Erection of 1 No. 4 bed dwelling, formation of new access & felling of 4 No. trees to the rear of the site. This application affects the character & appearance of the Craigweil House Conservation Area.

Land Between 8 And 12 Wychemood Close Aldwick

Objection to planning application AW/198/18/PL

Site Plan

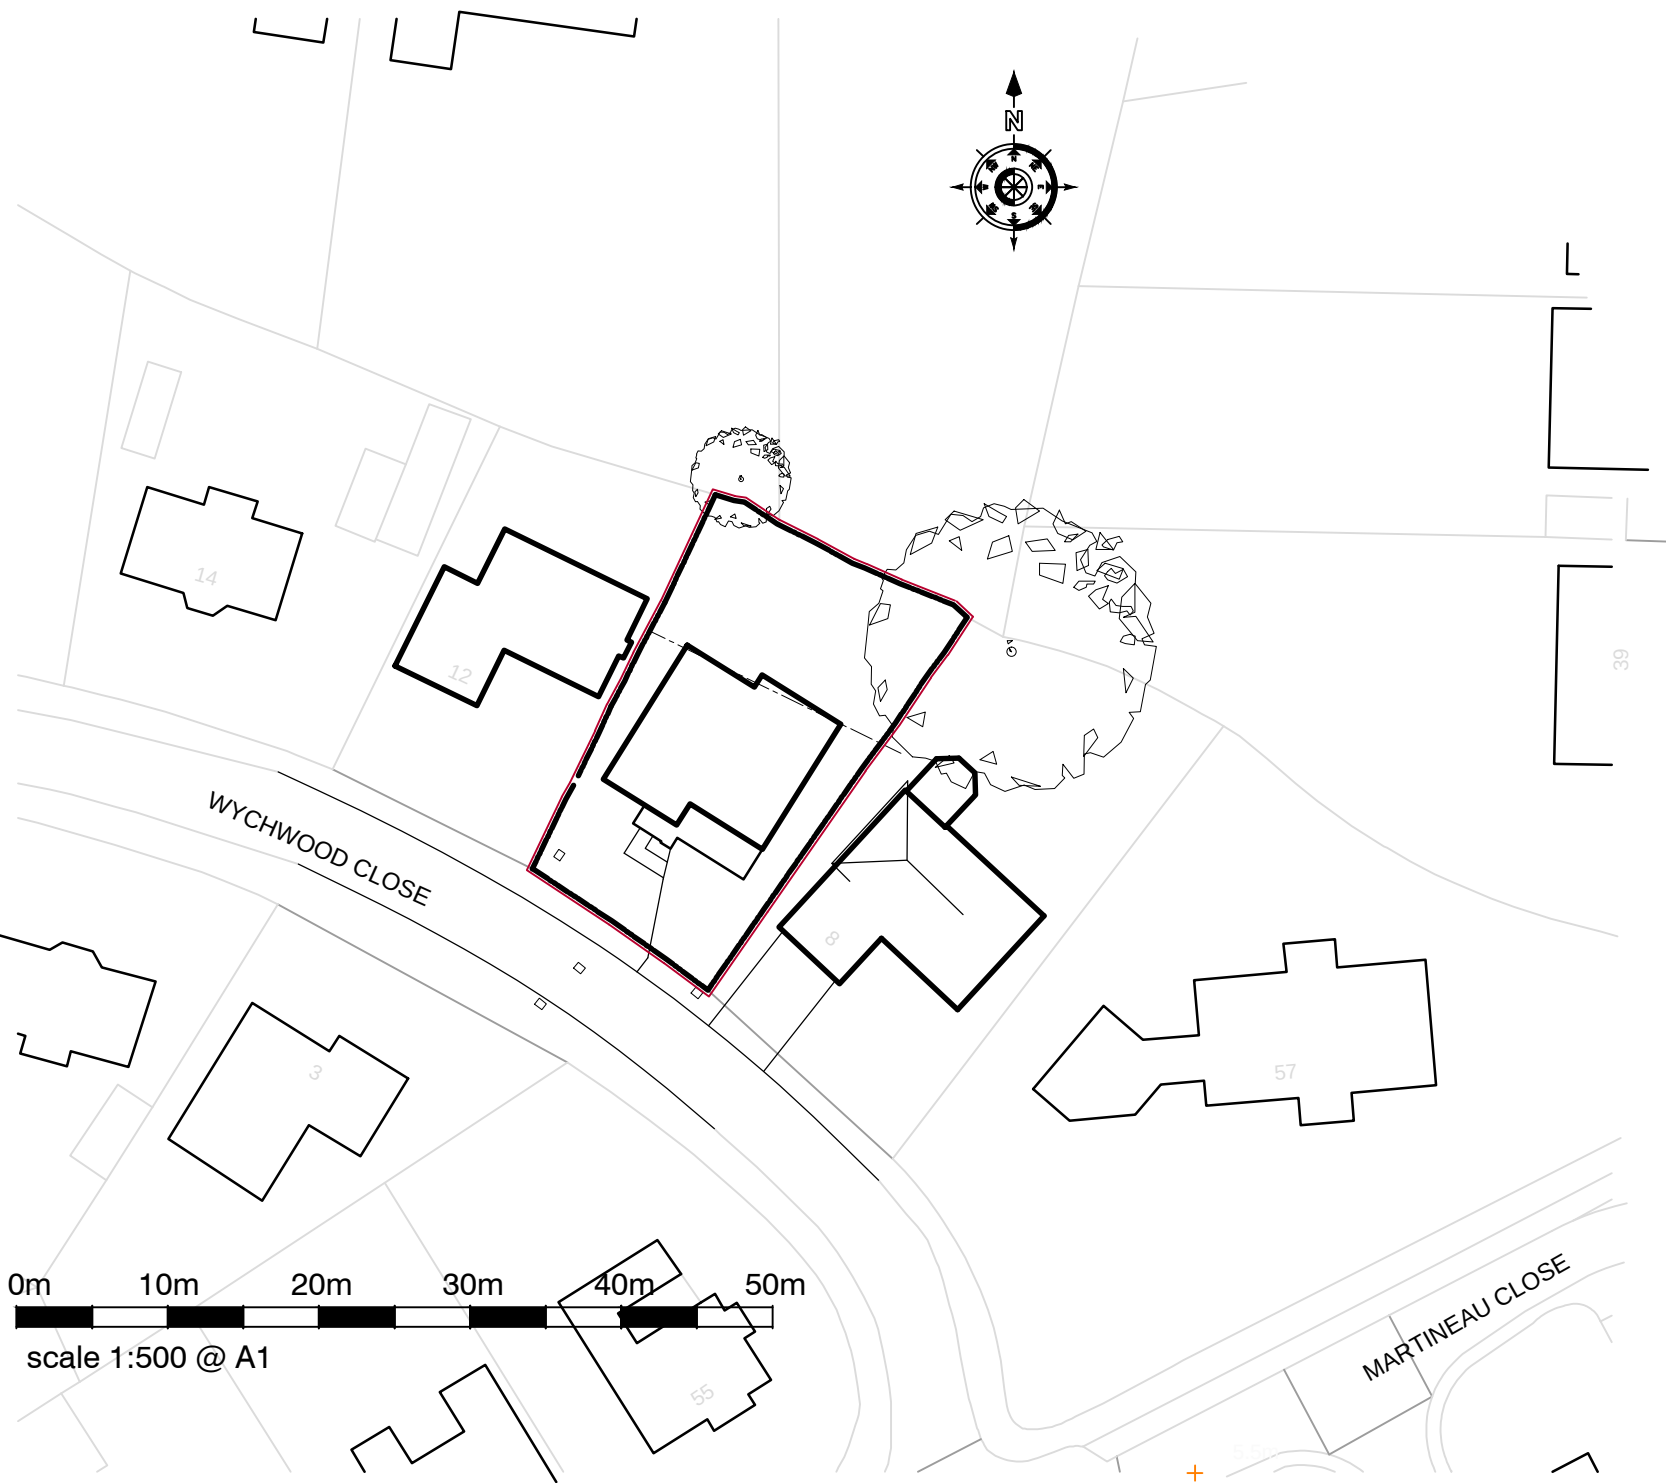
There is insufficient hard standing for the expected number of cars a house of this size may need to accommodate

South Elevation (front)

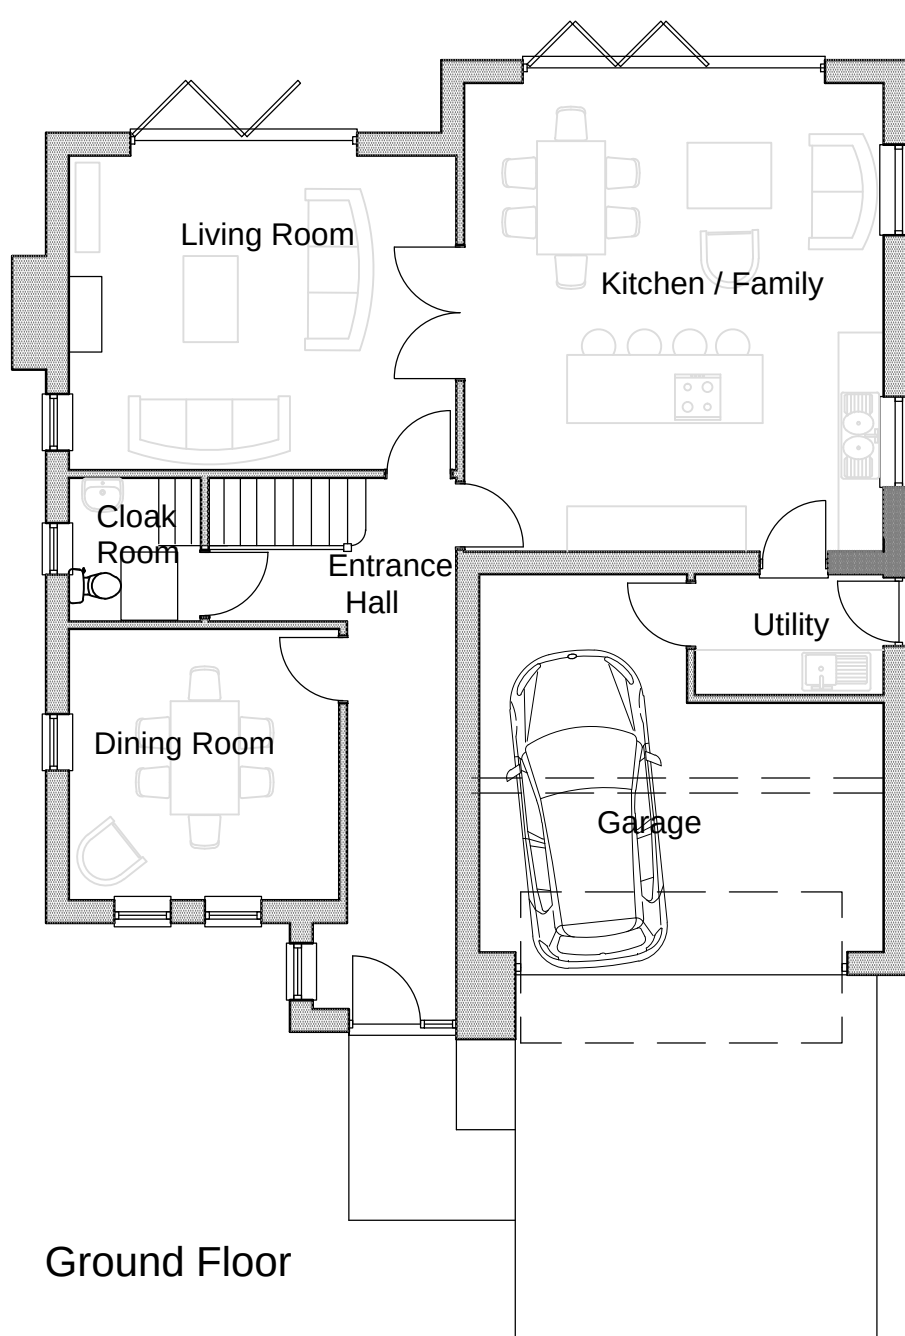
The property exceeds the established 1st floor line of development

Ground Floor

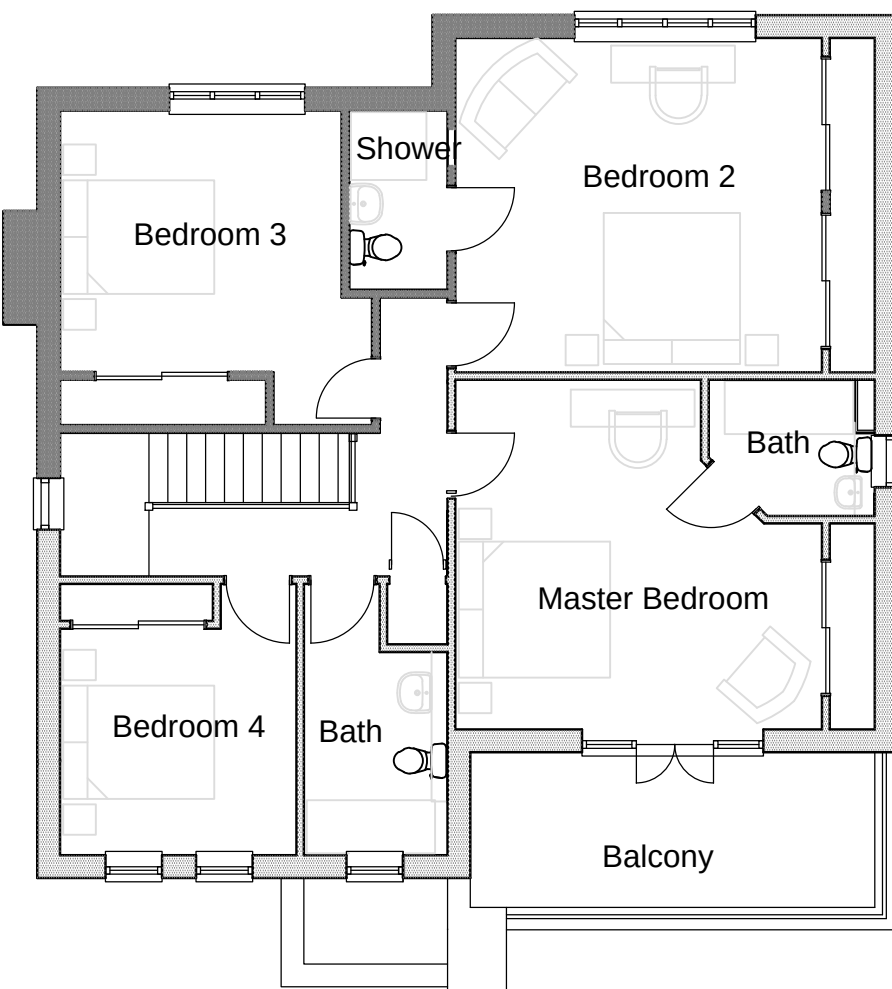
The internal layout compromises the internal garage space, thereby reducing its ability to house vehicles
